**NOTES - WATERMAIN, STREET, GRADING AND EROSION CONTROL
JCC BRIGE AT MAIN CHANNEL**

PROJECT: **JCC BRIDGE**
JCC MAIN CHANNEL - LORSON BLVD.
EL PASO COUNTY, COLORADO

GRADING AND EROSION CONTROL PLAN
JCC BRIDGE AT MAIN CHANNEL

**GRADING AND EROSION CONTROL PLAN  
 JCC BRIDGE AT MAIN CHANNEL**

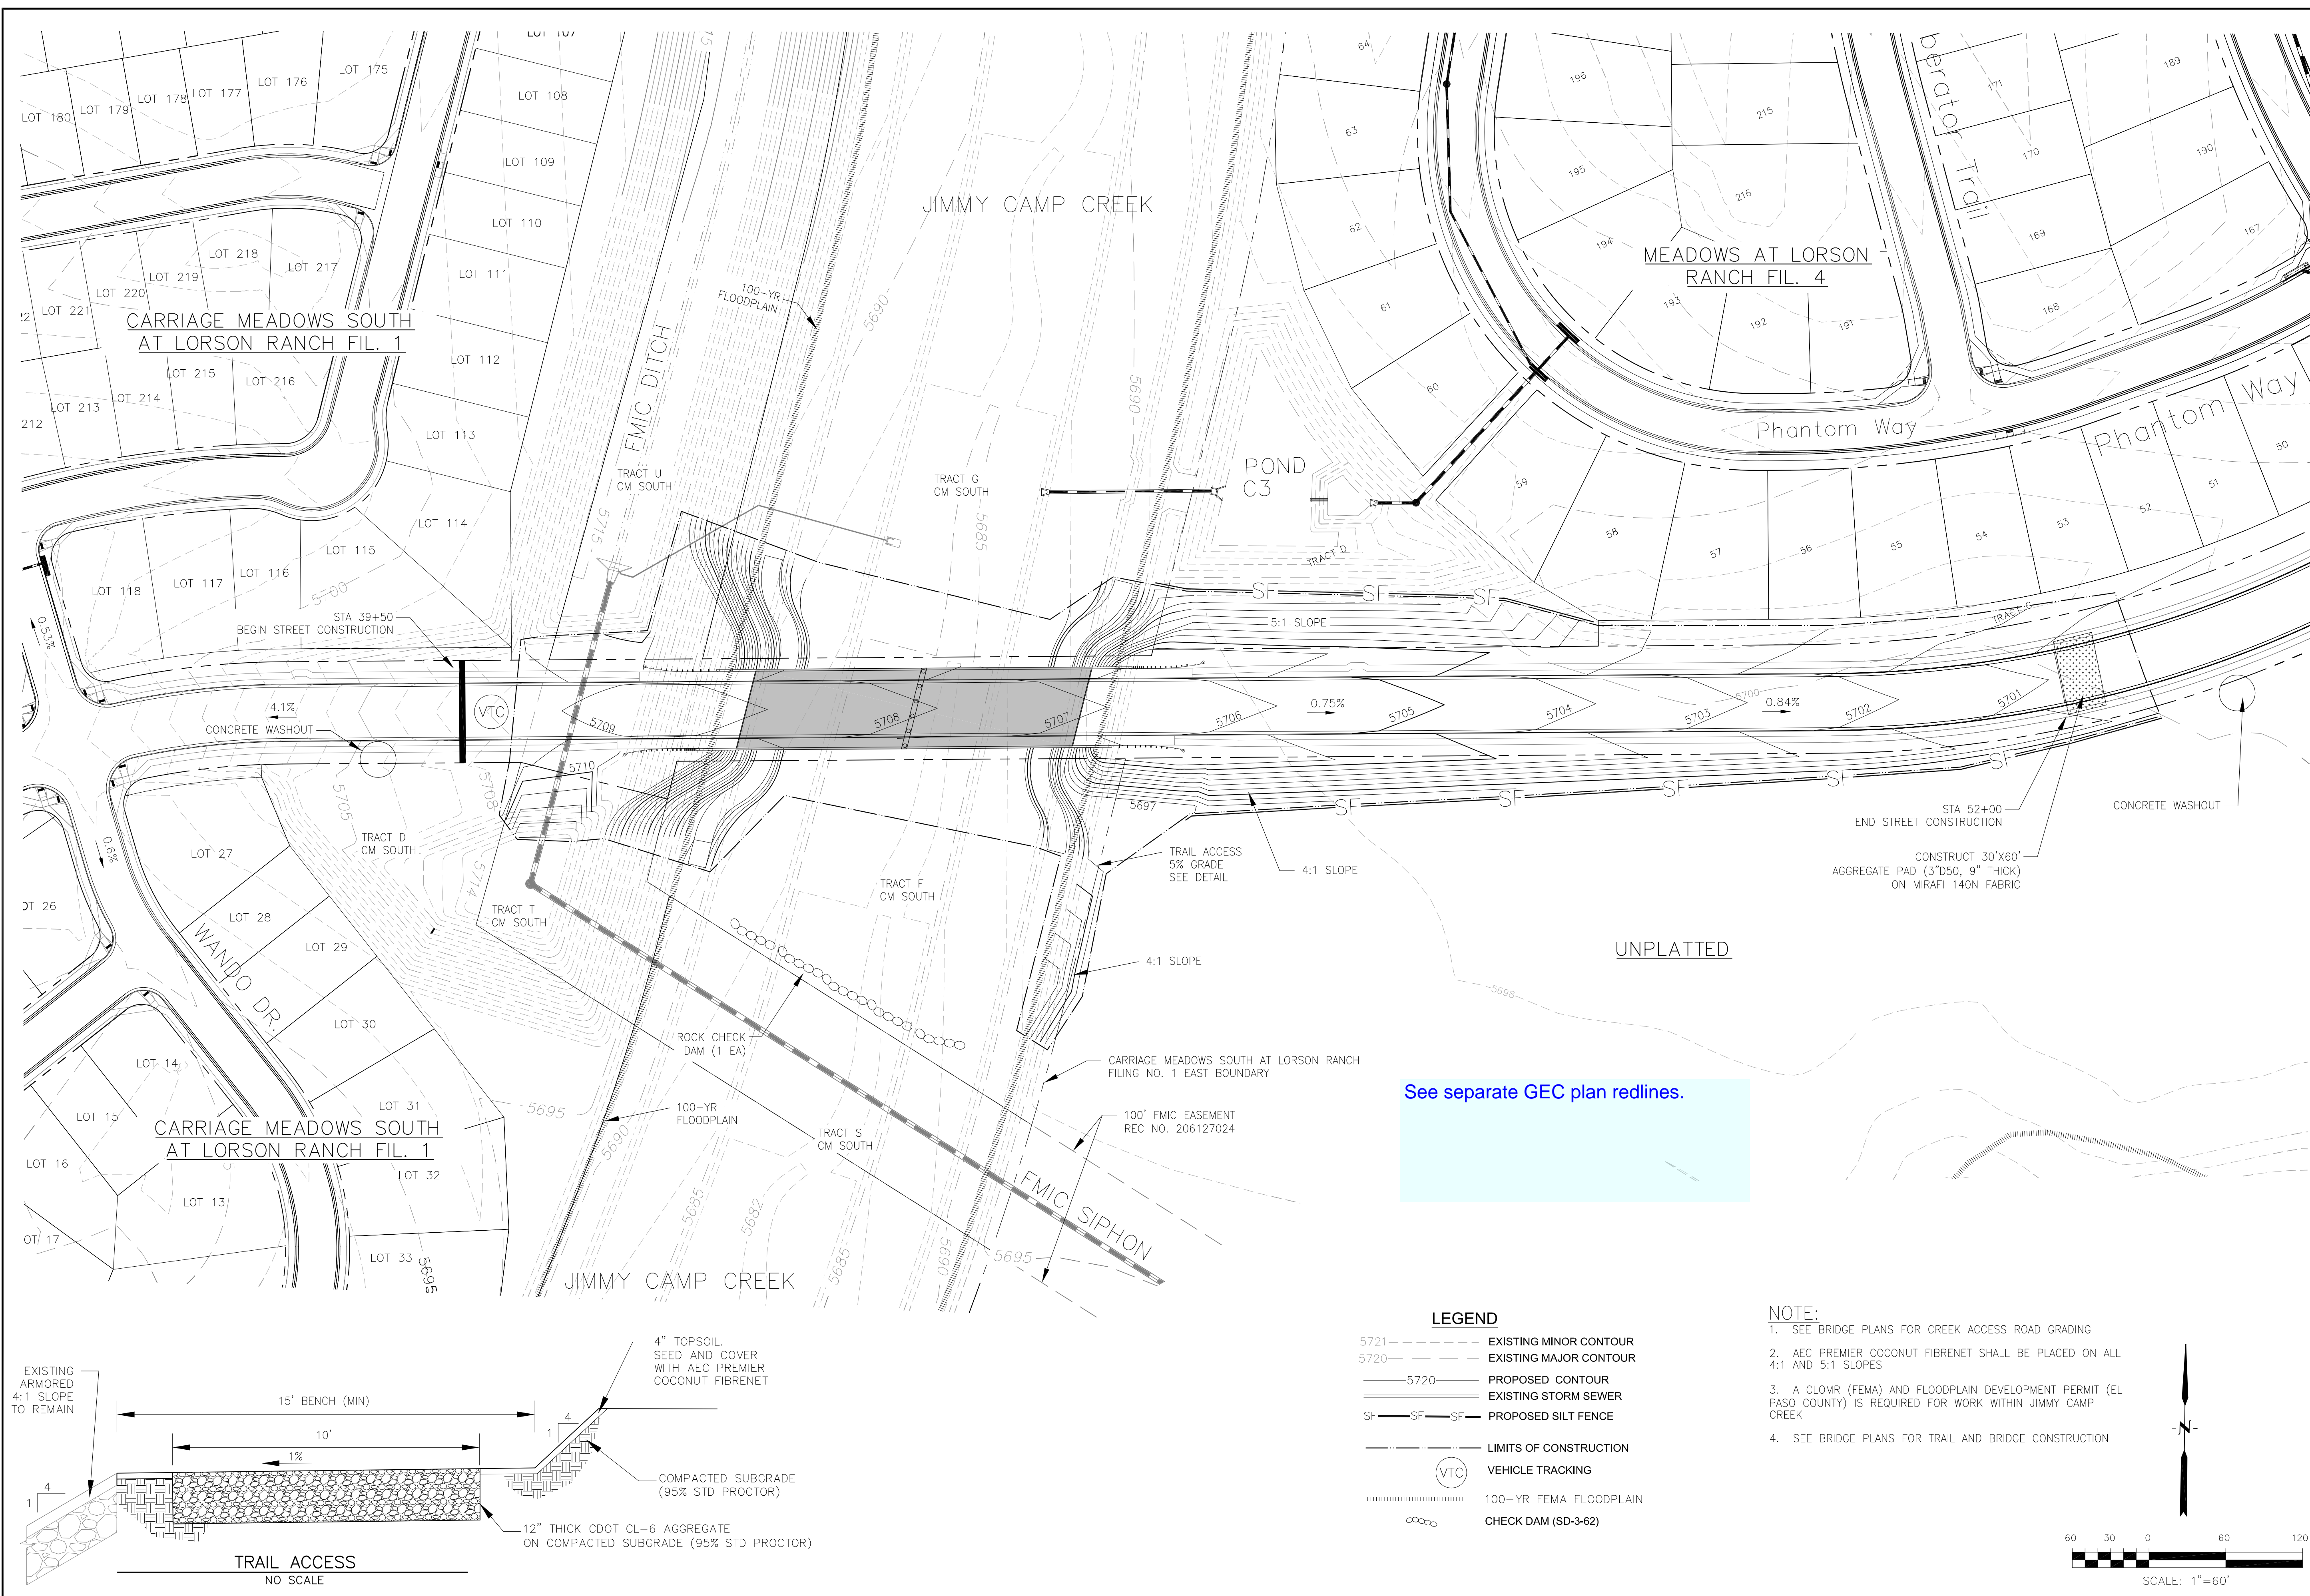
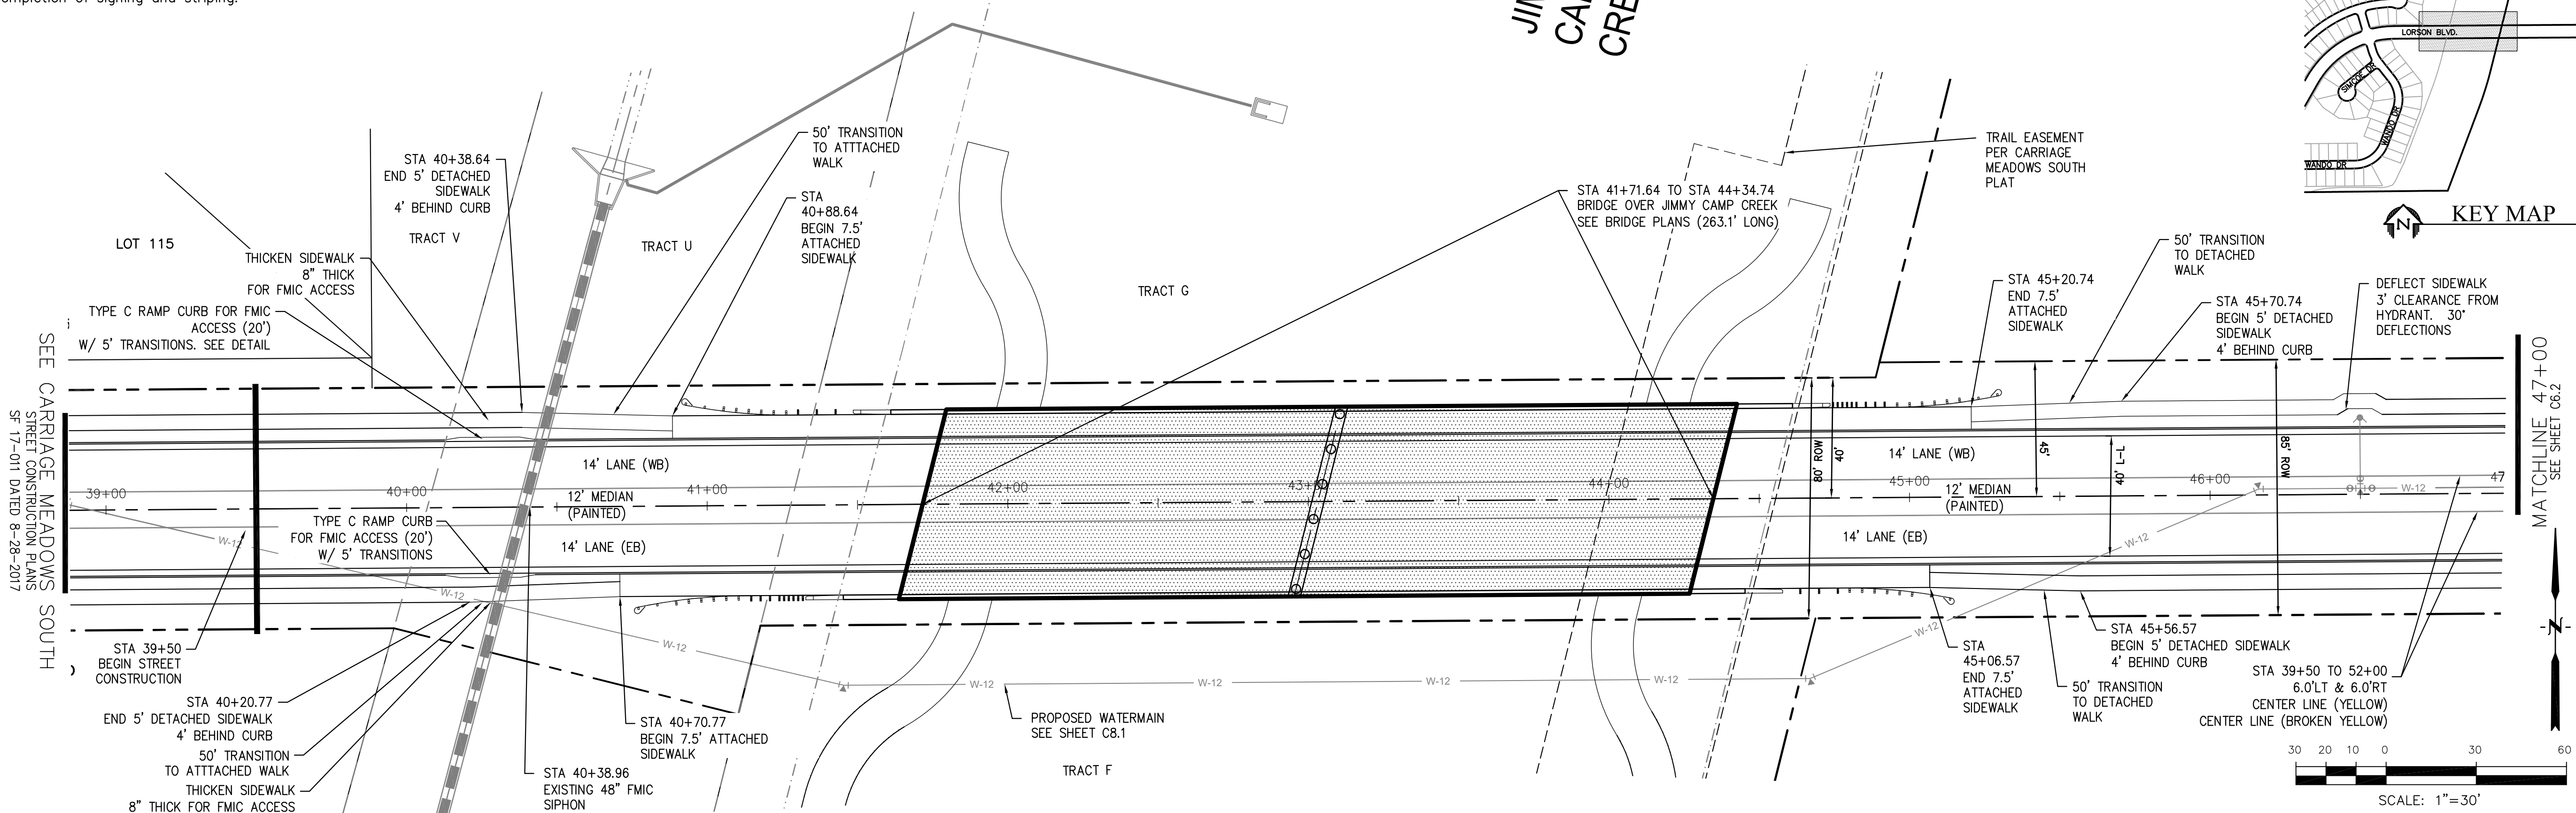
Provide actual cross-section across creek

Indicate VTC location

flow direction (?)

Provide flow arrows

Label slopes

This does not appear to be the best location for CWA - a lot of the site runoff appears to flow here.

TSB required (over 1 acre contributing area)?
